Case Officer: Hannah Kersley
Reference: AW/20/22/T
Location: Garden View Flat 3, Strange Garden House, Strange Garden, Aldwick, PO21 4AL
Proposal: 1no. holm oak tree (T1) - Crown lift to 4m. 1 No. Holm Oak tree (T2) - reduce all limbs at 3m to reduce by 1.5m to leave 1.5m
Reasons given: None provided

REF 1

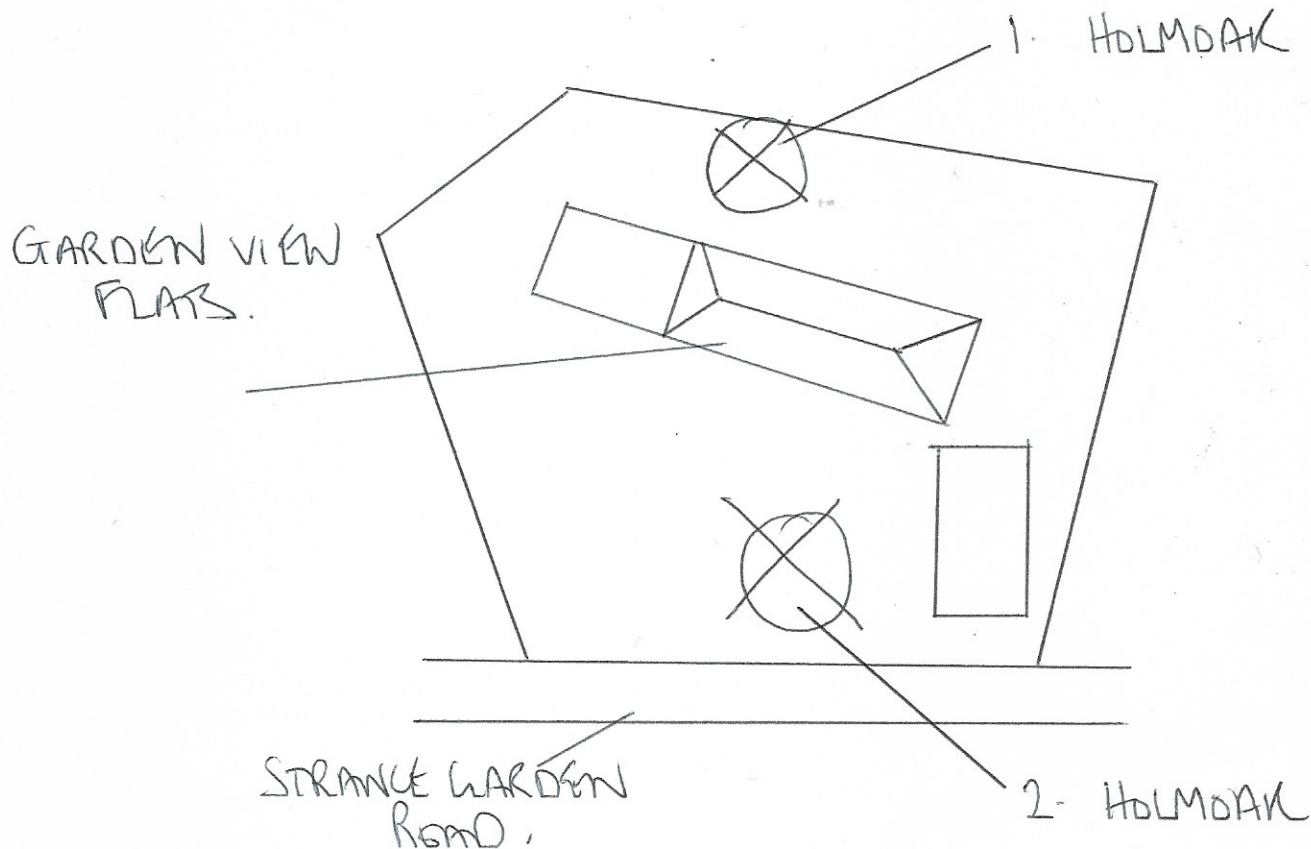
- Outwardly both trees appear to be in a fine physiological state. T1 is located far east of the location marked on the sketch plan, beyond the gated garden boundary. It is the only holm oak in the immediate locality (rear garden areas) so is assumed to be a concern.

- The work specification is ambiguous but assumed to propose a repeat of past crown reduction. The extent of work can be controlled by condition (see below) to ensure the tree is not unduly harmed by excessive pruning.
- The proposal to reduce overall height and spread with a view to restricting its growth is consistent with previous work approved by the Local Planning Authority.
- While a temporary loss of aesthetic value is inevitable, satisfactory canopy renewal and recovery should occur if the work is undertaken to a high standard and at an appropriate time of year.

- I recommend **CONSENT** is granted subject to the following condition:

Part a) Where whole branches are to be removed and final cuts made close to the trunk or branch union they are to be made as shown in Figure 2 of BS3998:2010

Part b) Where branches are to be shortened back the final cuts are to be made at the correct angle shown in BS3998:2010 and adjacent to a live bud or lateral.

Part c) The removal of crown material which has developed since the last operation must be done sympathetically and with respect to established 'knuckles' so as not to extend beyond the point of origin.
